Ribble Valley Borough Council  
Housing & Development Control

Application no: **3/2024/0060**

Proposal: **Approval of details reserved by conditions 7 (Construction Traffic Management Plan) and 15 (Construction Surface Water Management Plan) of planning permission 3/2023/0305.**

The Local Highway Authority have viewed the plans and highway related documents and have the following comments to make:

Details of the construction access including location, design and surfacing.

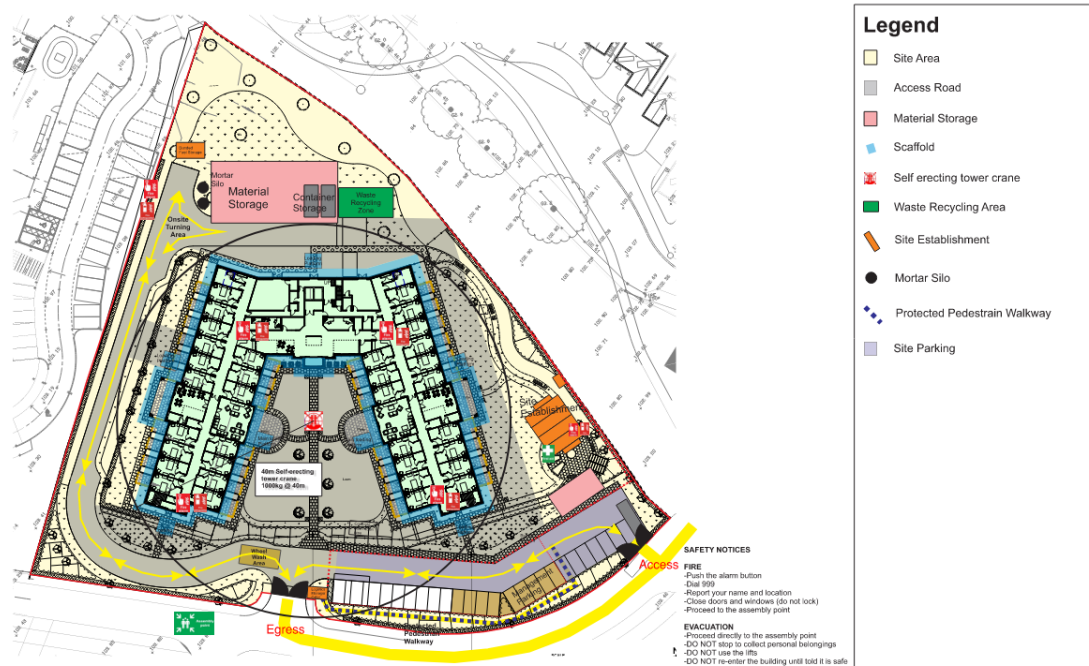
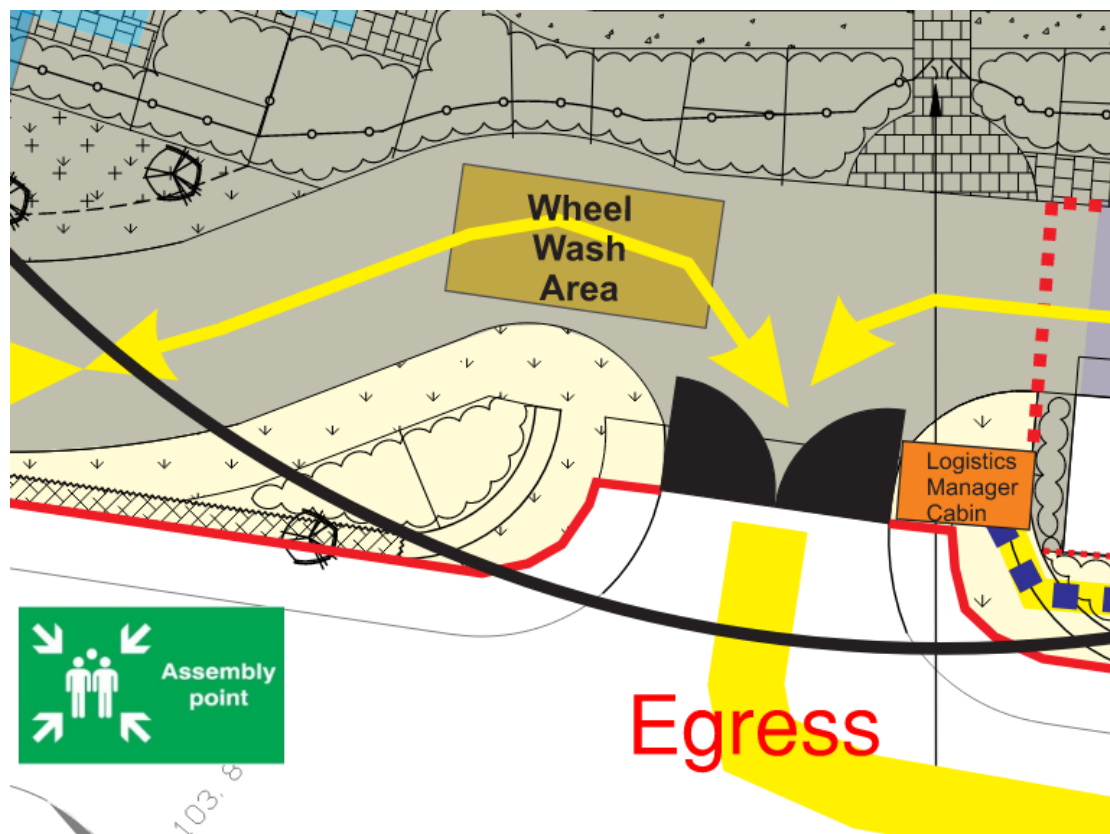
The LHA have reviewed the provided Construction Traffic Management Plan provided by Eric Wright and object to the discharge of condition. This is because the LHA do not see the need for a temporary secondary access to be provided to serve the development during the construction phase. Therefore, the LHA require the site to use the already approved access which has already been constructed as part of the Higher Standen development when serving the site. As a result, the change to the access arrangements need to be shown on a revised plan.
